**Lead Local Flood Authority**  
**Post Point CHN 215**  
**Hertfordshire County Council**  
**County Hall, Pegs Lane**  
**HERTFORD SG13 8DN**

Date 28 October 2022

**RE 6/2022/1853/MAJ - Eisai Europe Limited, European Knowledge Centre, Mosquito Way, Hatfield, AL10 9SN**

Proposed Surface Water Drainage Layout Option 1 (ESL-ACM-XX-ZZ-DR-C-0501)

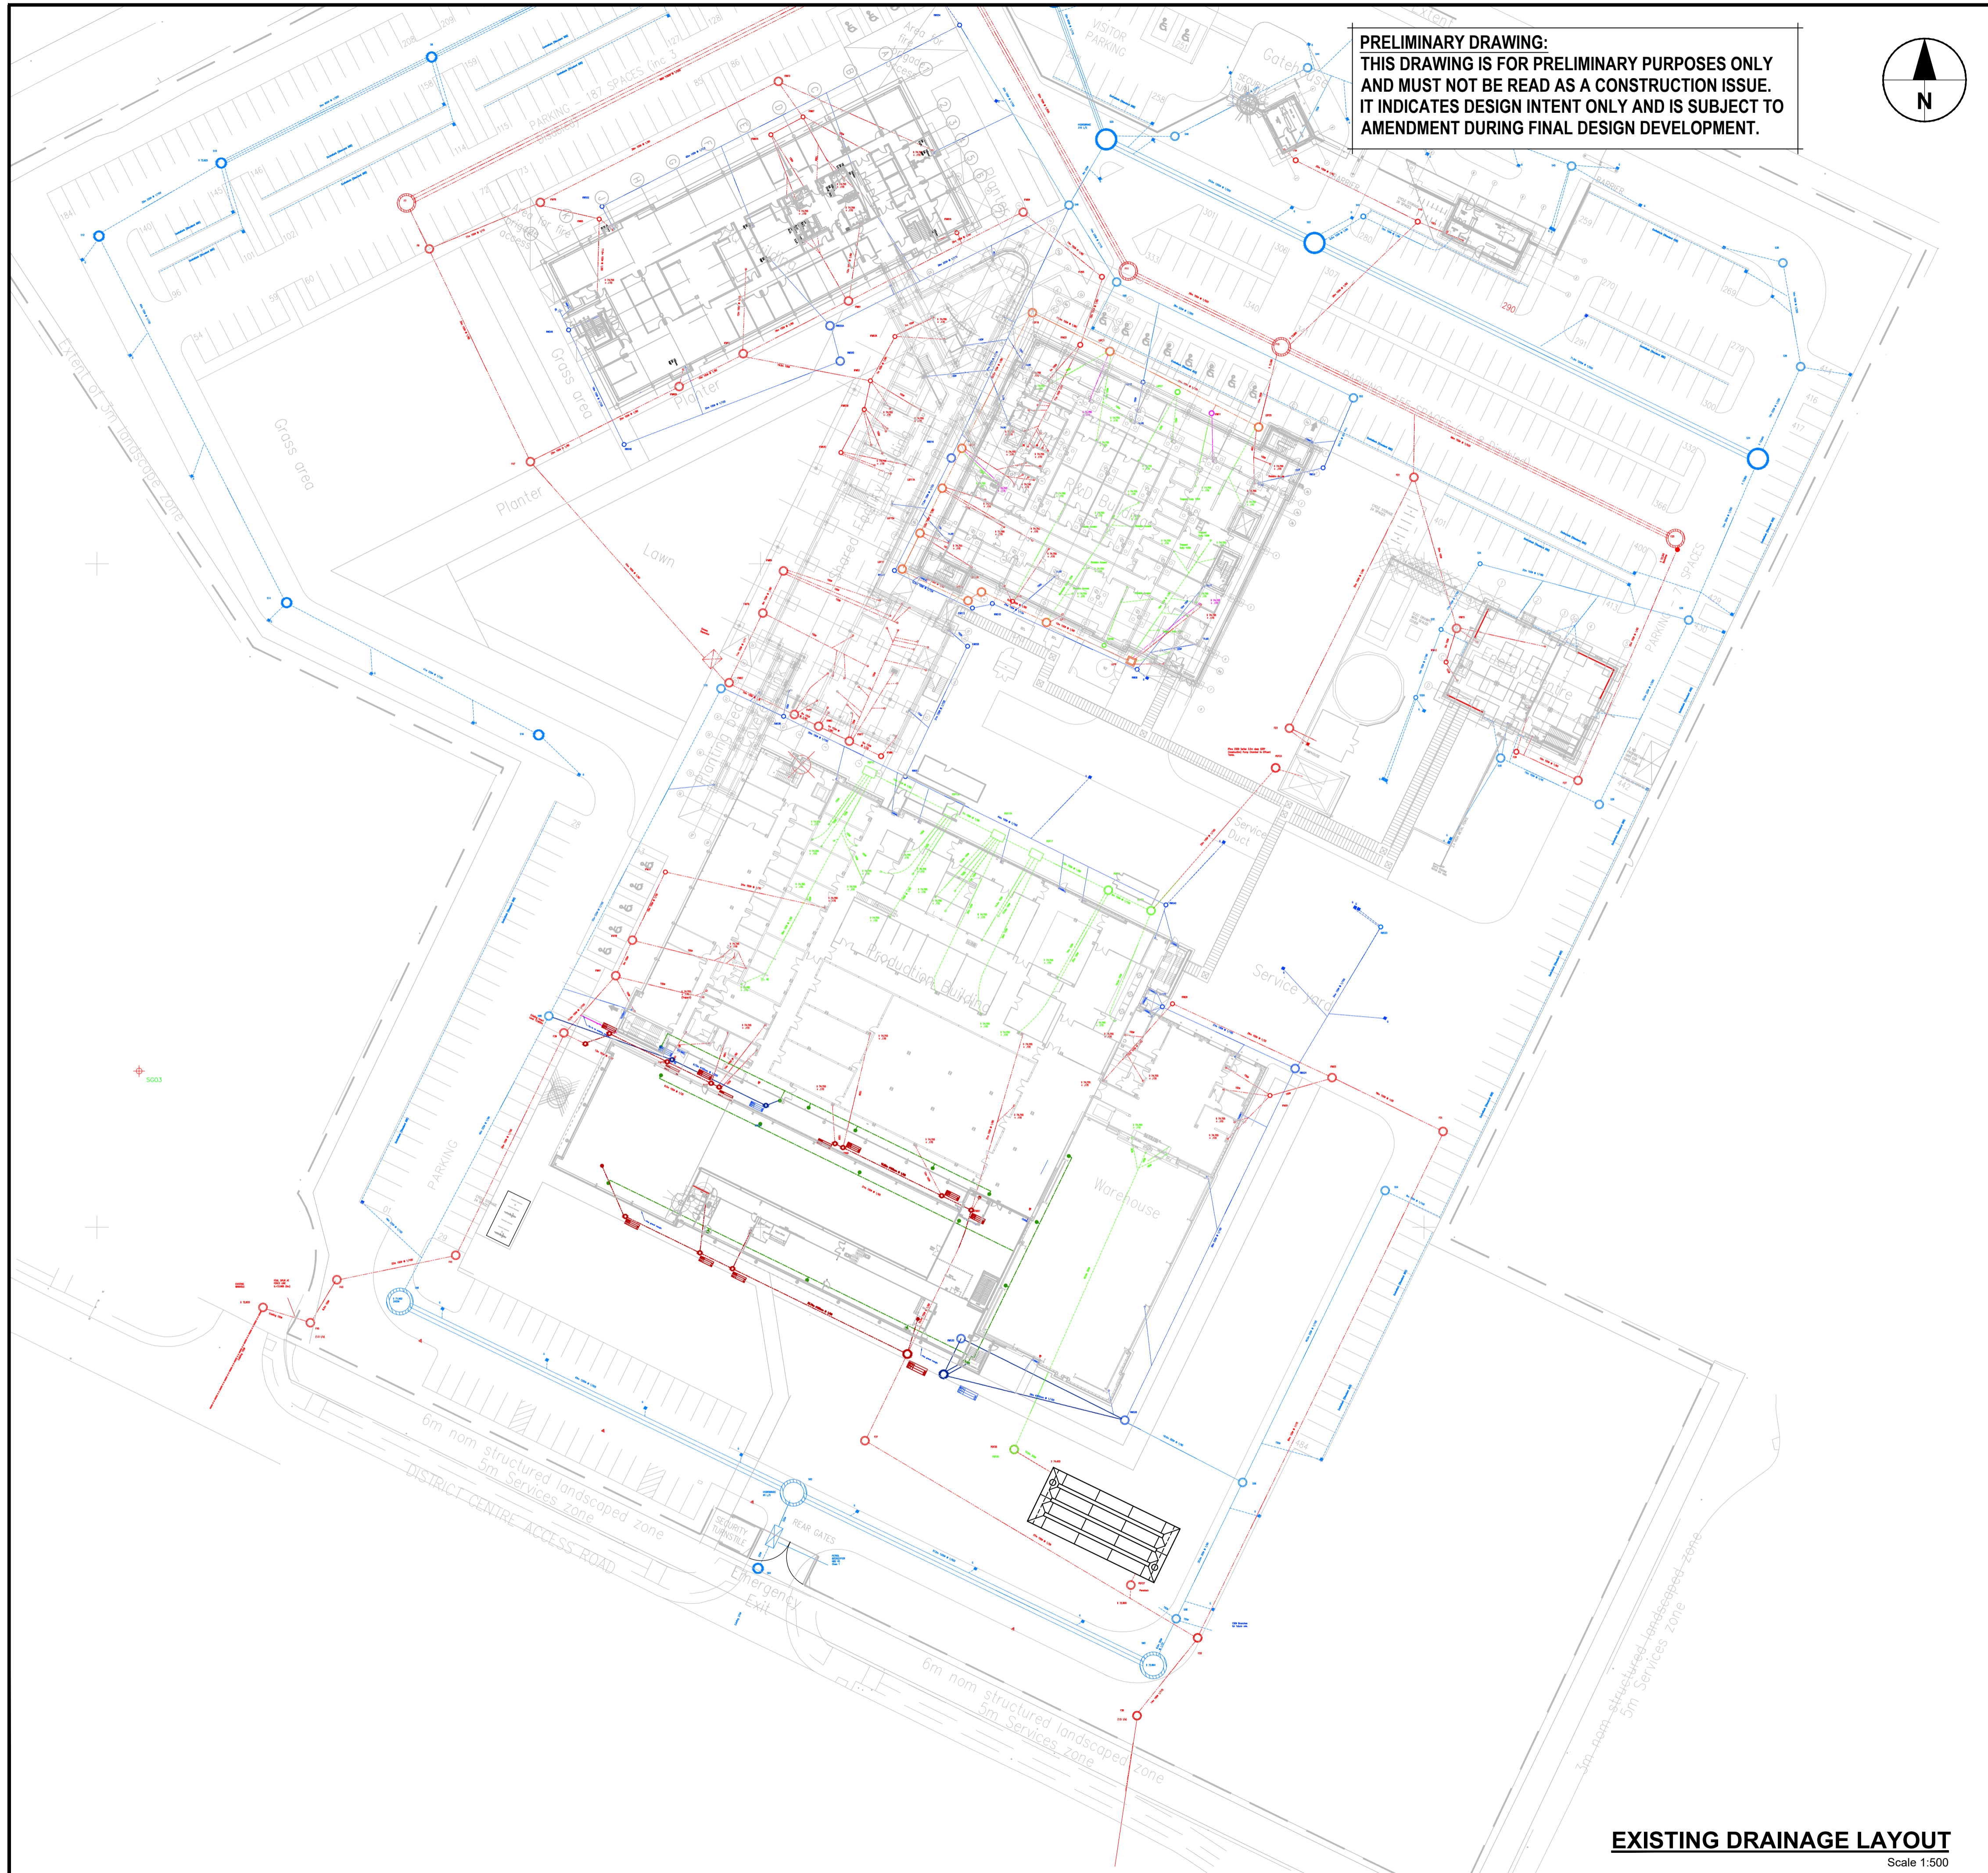
- e. Three different drainage strategy options have been provided. No definite solution has been identified and no discussion around the different approaches was undertaken with Thames Water. As this is a full planning application a single drainage design should be submitted that identifies specific details of the design including conveyance and storage elements of the network. Quick Storage estimate is not acceptable. Details of pre and post development runoff rates and volumes should be evidenced. We request that the discharge is limited to greenfield runoff rates and volumes unless lower rates to prevent surcharge of the existing drainage system is required. Evidence of this assessment should be submitted and a in principal agreement with Thames Water if the development will increase the current discharge or creating a new connection to their network.

- f. Full detailed drainage layout plan showing the proposed SuDS features, any associated manhole cover and invert levels, proposed ground levels, pipe sizes and gradients, all on-line controls, on-line and off-line storage structures, water quality mitigation and outfall details.
